**Office of
Environment
& Heritage**

DOC18/893817
SSD 9273

**Notice of Exhibition - Redevelopment of Wentworthville Public School, 70-100 Fullagar Road,
Wentworthville - SSD 9273**

Attachment 1 – OEH comments - Exhibition of Wentworthville Public School Redevelopment, 70-100 Fullagar Road, Wentworthville - SSD 9273

Plan by Fulton Trotter Architects, Project No: 768WV01, Dwg No:SD-1001/Rev P8, Level 3, Dated 05/10/18

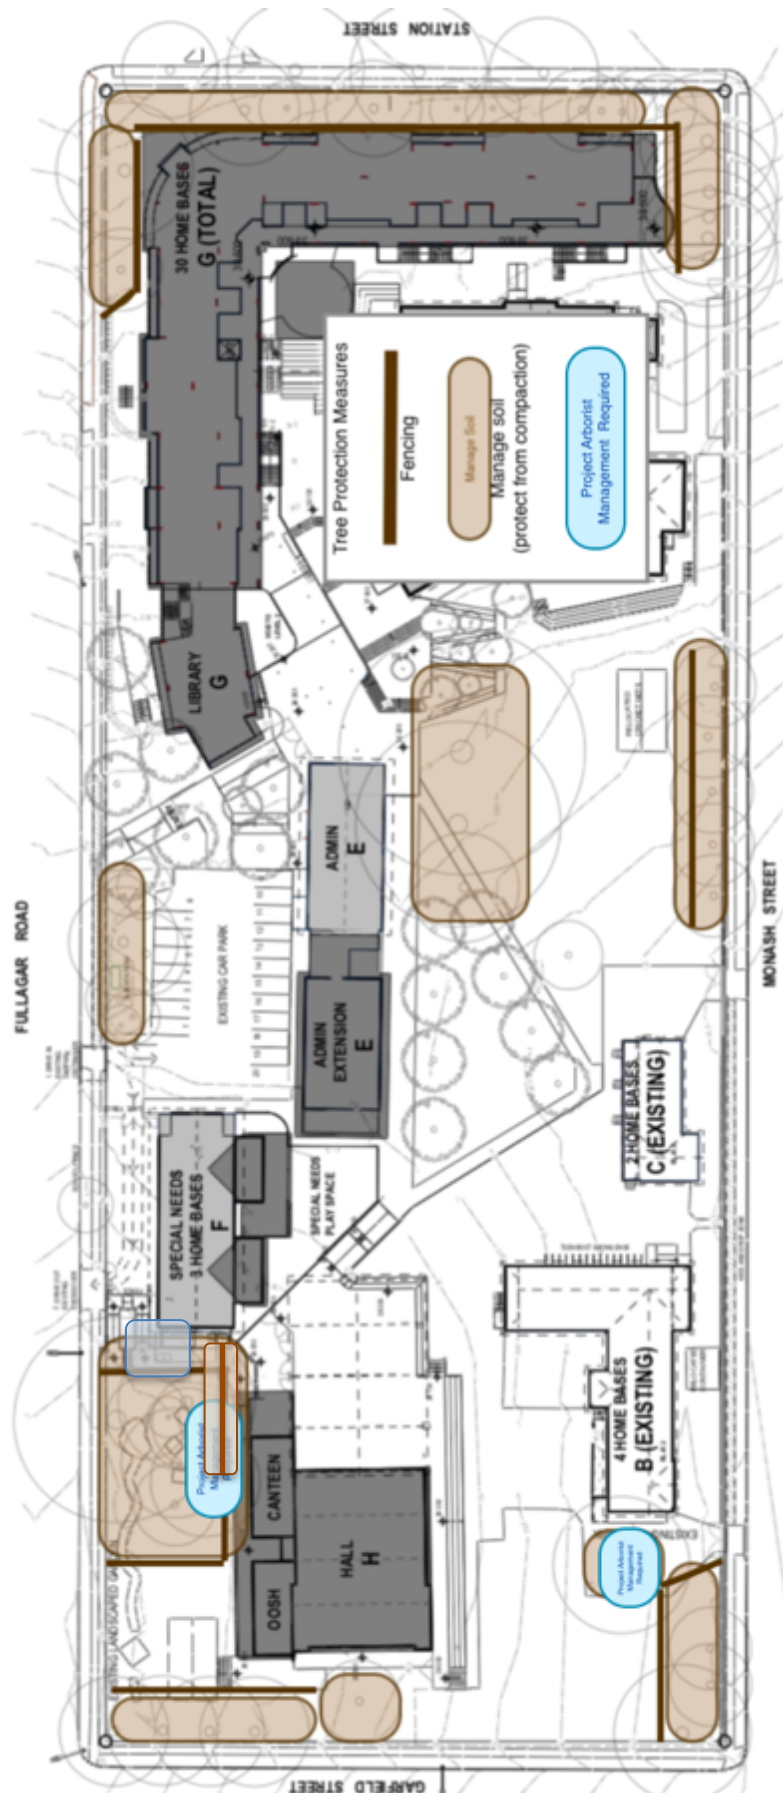
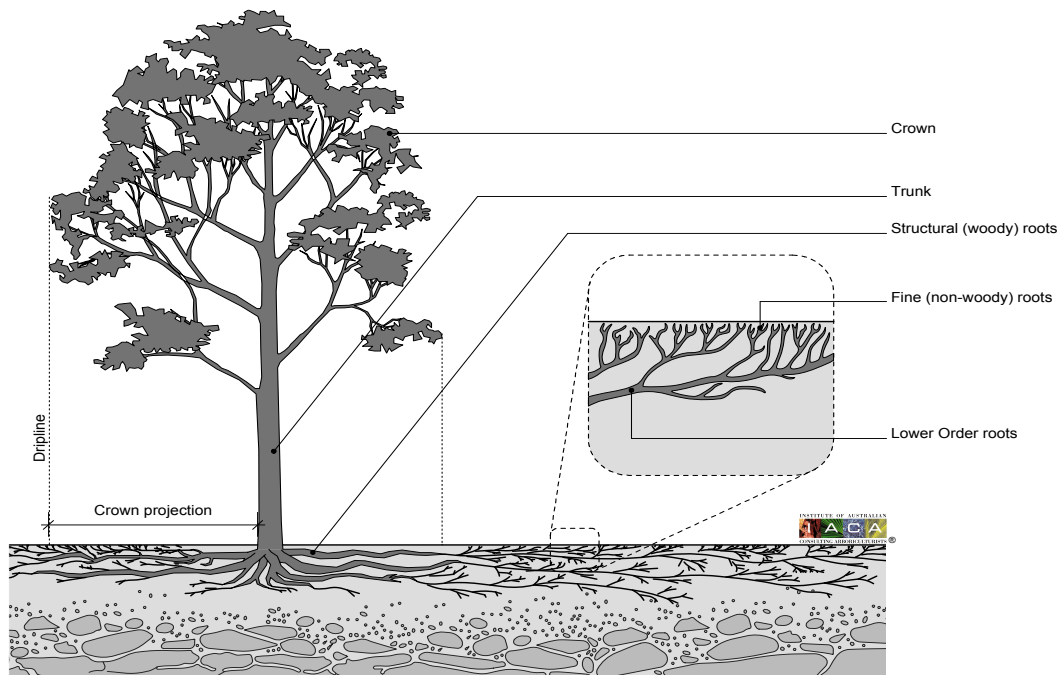
The plans show conflicting information on the extent of tree removal/retention. The arborist reports site demolition plan in Appendix A1 and Tree removal/retention plans- Appendix A2ii conflict with the landscape plans tree removal and retention plan. The arborist report plans are unreadable making it difficult to determine which trees correspond with the Tree numbers and the condition of the trees as detailed in the tables in the arborist report.
